LEGAL DESCRIPTION:
TRACT 1-B2, FOUR HILLS VILLAGE SHOPPING CENTER AND APT COMPLEX

ENGINEER'S SEAL	BEEHIVE HOMES	DRAWN BY WCVJ
		GRADING AND DRAINAGE PLAN	DATE 6-13-13
			21227-LAYOUT-7-13-12
DAVID SOULE P.E. #14522		1606 CENTRAL AVENUE SUITE 201 ALBUQUERQUE, NM 87106 (505) 872-0989	SHEET # 1
			JOB # 21227

ENGINEER'S SEAL  DAVID SOULE P.E. #14522	BEEHIVE HOMES	DRAWN BY: WCWJ
	GRADING AND DRAINAGE DETAILS	DATE: 6-13-13
	 Rio Grande Engineering 1606 CENTRAL AVENUE SUITE 201 ALBUQUERQUE, NM 87106 (505) 872-0999	21227-LAYOUT-7-13-12
		SHEET # 2
		JOB # 21227

SECTION A-A
NTS-- Prior to cutting wall, pouring concrete, contractor shall notify the storm drain inspector, Jason Rodriguez--857-8074, to inspect work in progress.

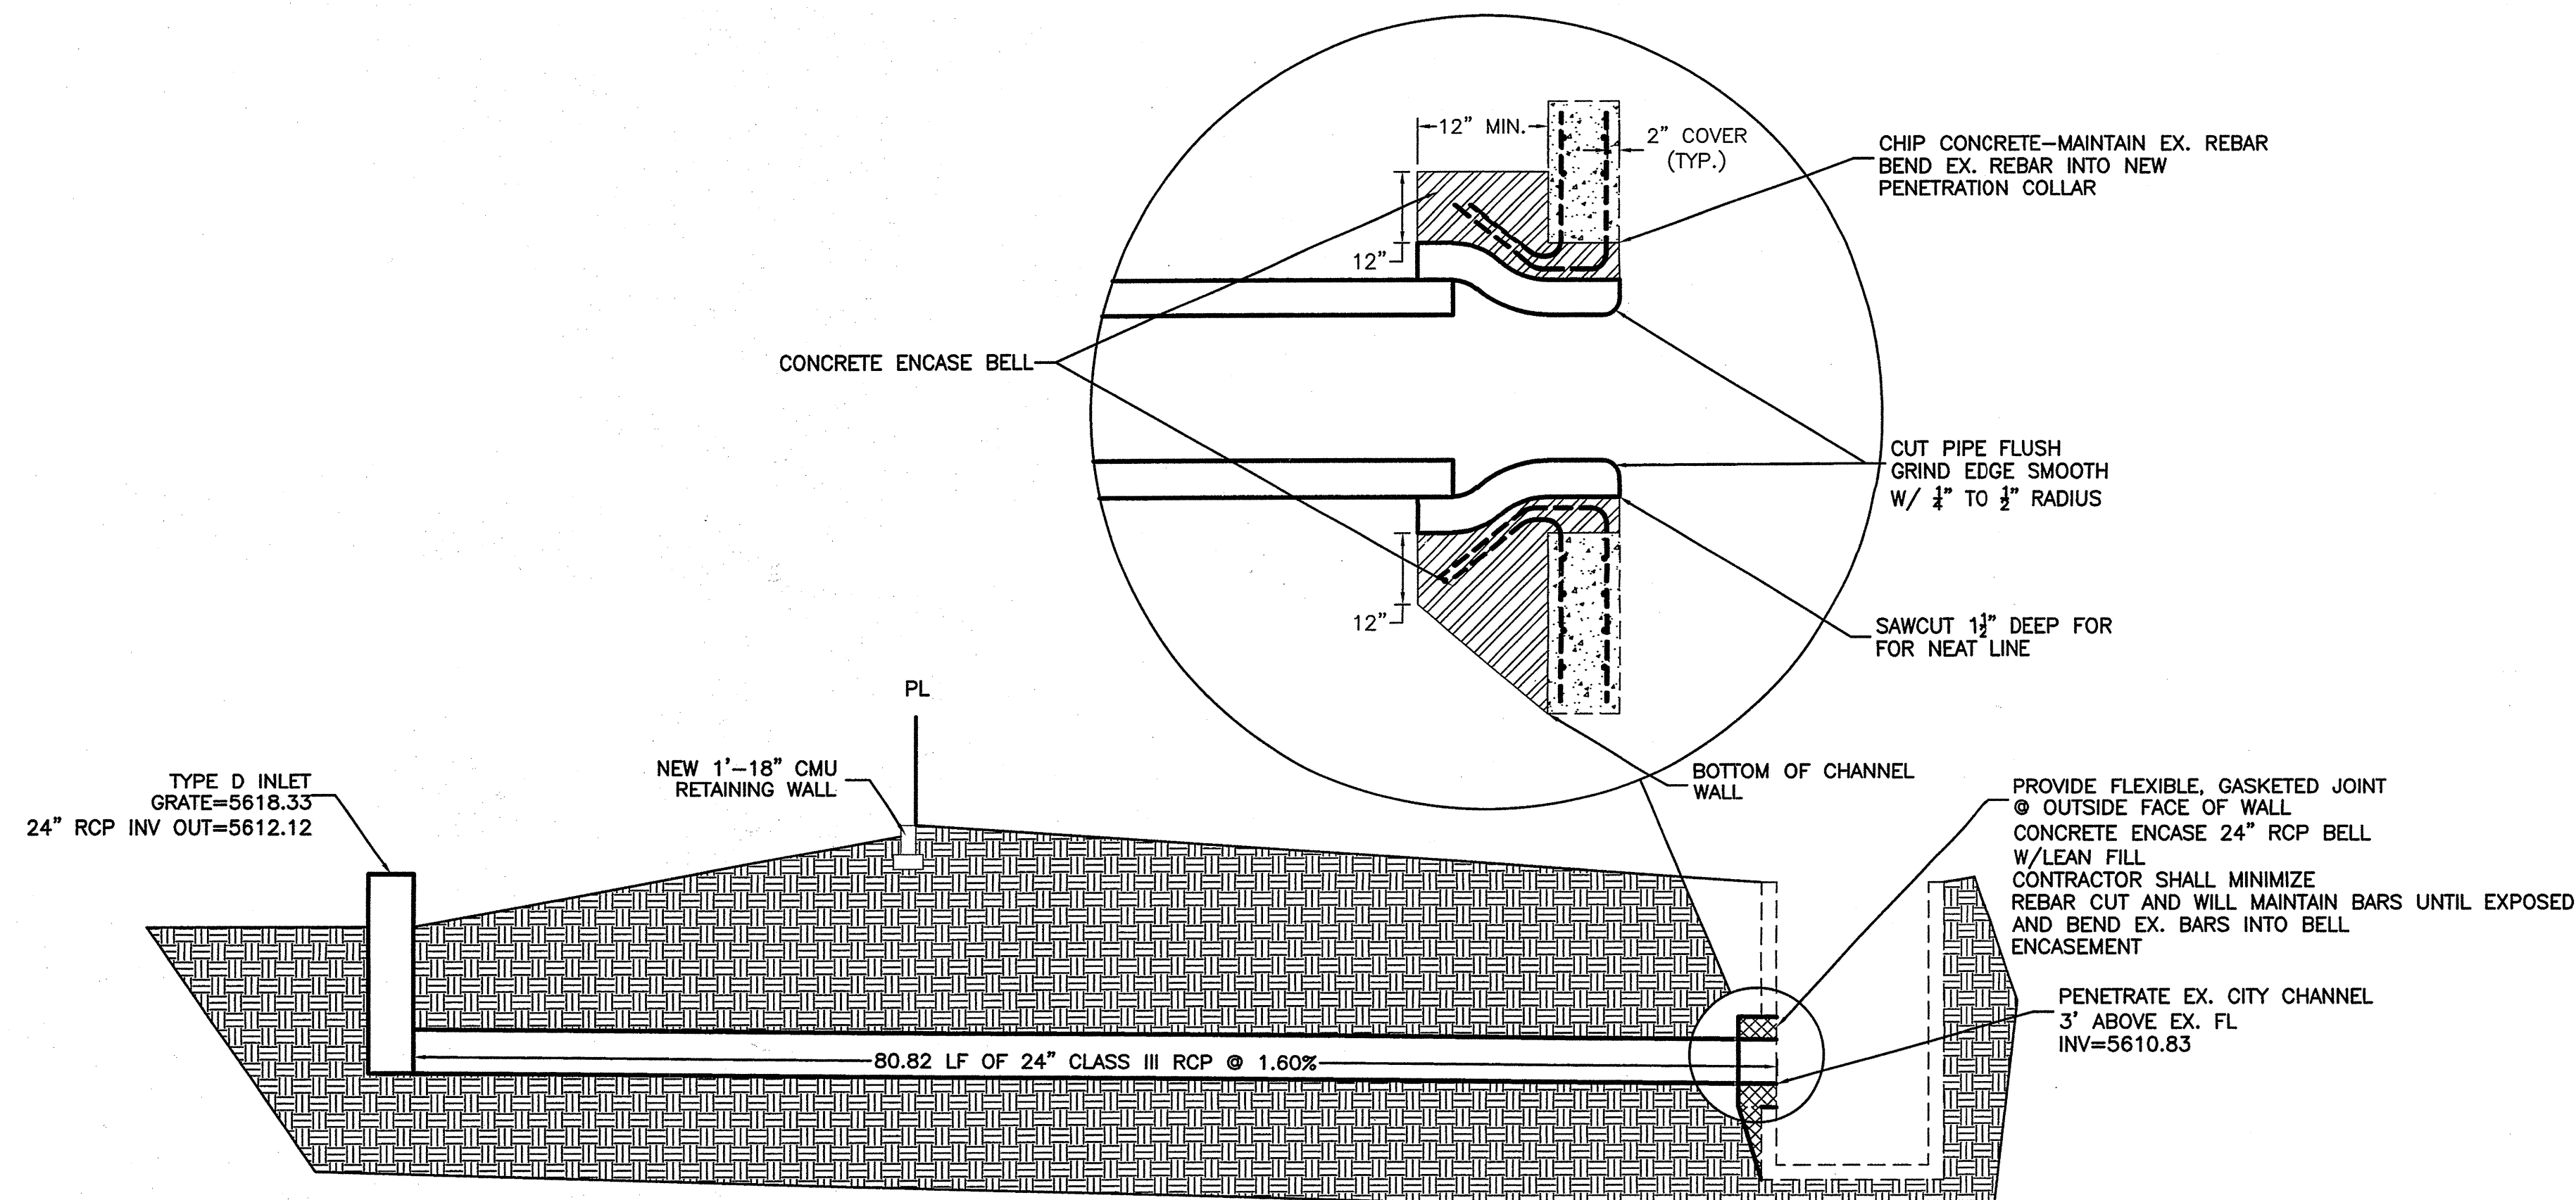
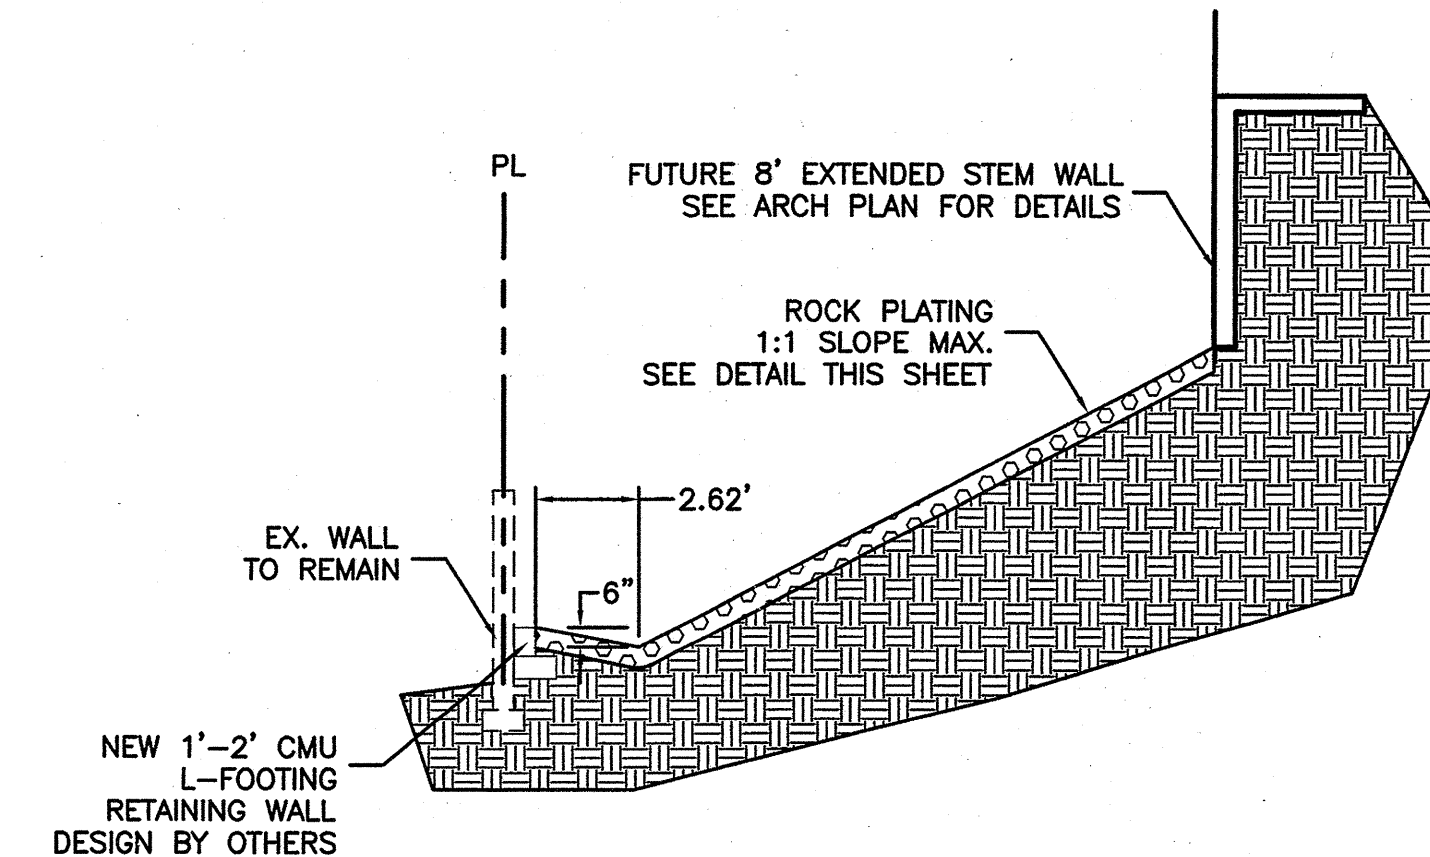
Revised per Pond changes & reduced Q. Direct spillway to match existing concrete south from Pond location.

Cutting of Wall & Rein & Conc. must be inspected by Storm Drain Maint. by Jason Rodriguez 857-8074

ENGINEER'S SEAL	BEEHIVE HOMES	DRAWN BY WCUJ
DAVID SOULE NEW MEXICO REGISTERED PROFESSIONAL ENGINEER 14522	GRADING AND DRAINAGE PLAN	DATE 10-02-13
	Rio Grande Engineering 1606 CENTRAL AVENUE SUITE 201 ALBUQUERQUE, NM 87106 (505) 872-0999	21227-AYOUT-7-13-12
		SHEET # 1
		JOB # 21227

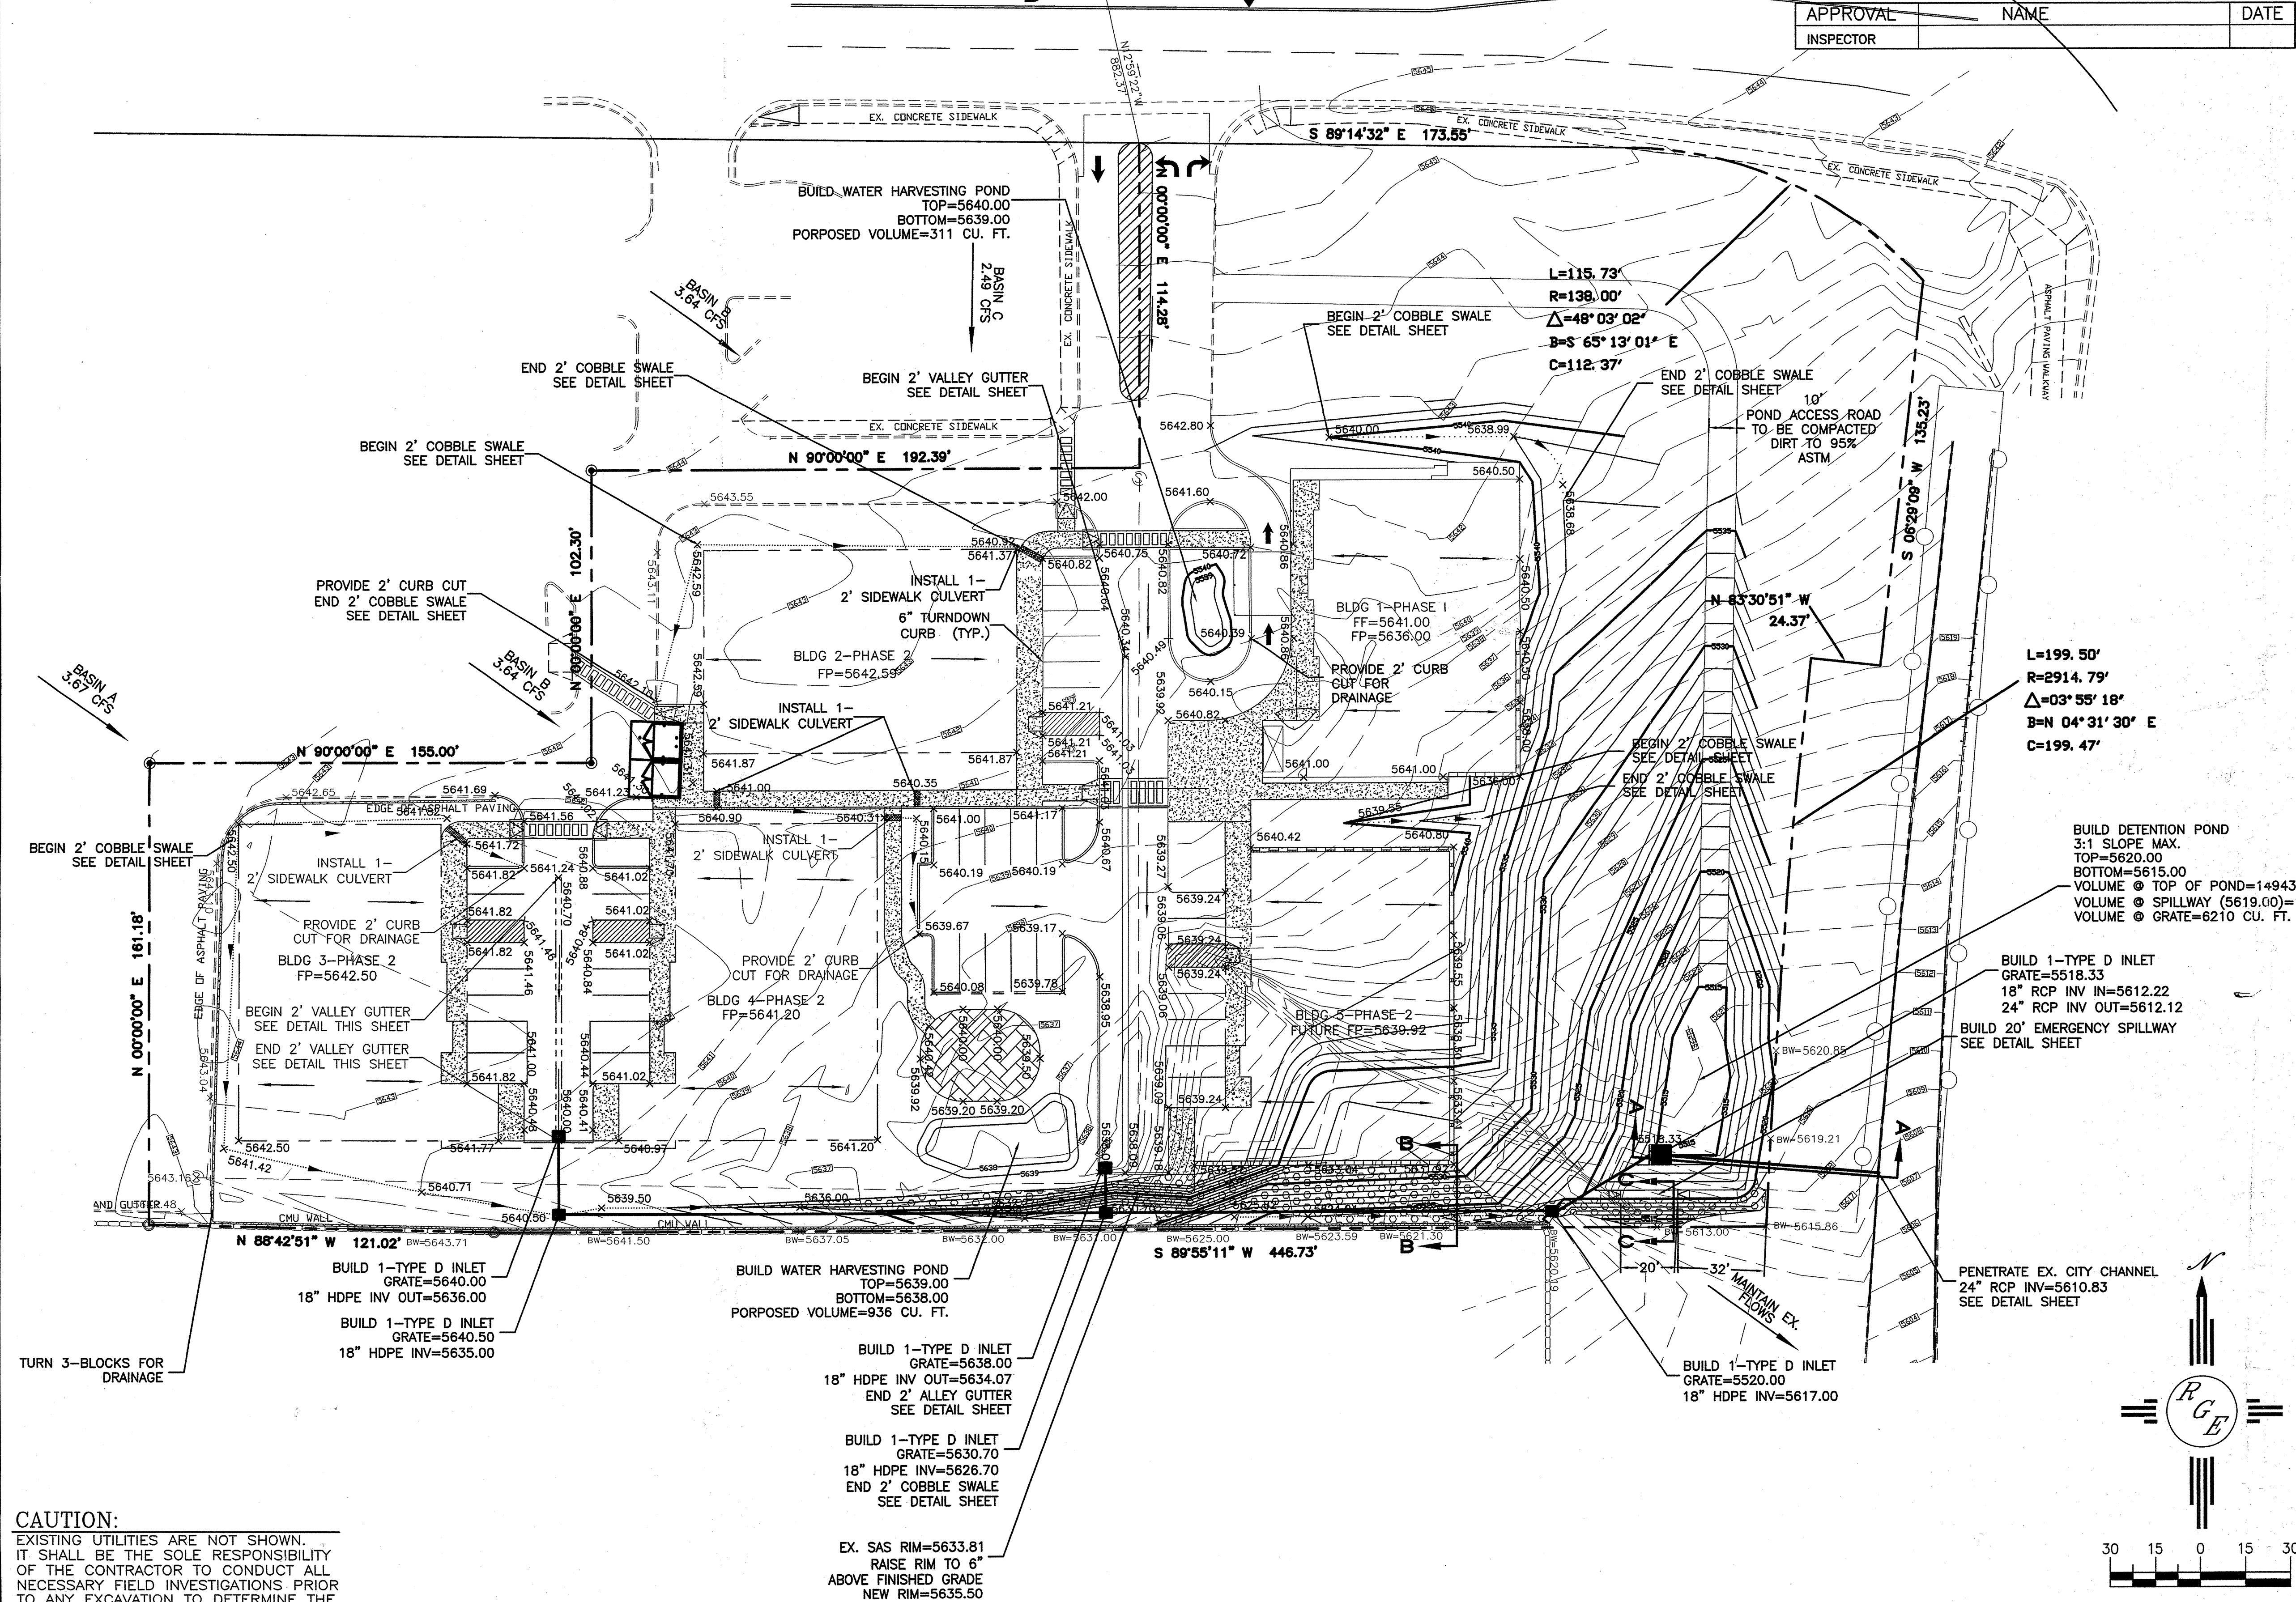
Show where roof drainage packages 1, Typoed

How does water get into ponds & where is overflow?

Show where off-site flows enter site & label Q's Address HOW off-site flows are conveyed

Clarify limits of Cobble Swale(s)

- NOTES:**
1. ALL SPOT ELEVATIONS REPRESENT FLOWLINE ELEVATION UNLESS OTHERWISE NOTED.
2. * DENOTES THAT FOR MASS GRADING FINISHED PAD SHALL BE FINISHED FLOOR MINUS 1'. AT THE TIME OF FINAL CONSTRUCTION PAD EXCAVATION SHALL BE TO DESIGN PAD ELEVATION. *Clarify how this will work with extension over excavation discussed by contractor 8/28/13.*

Differentiate Symbols
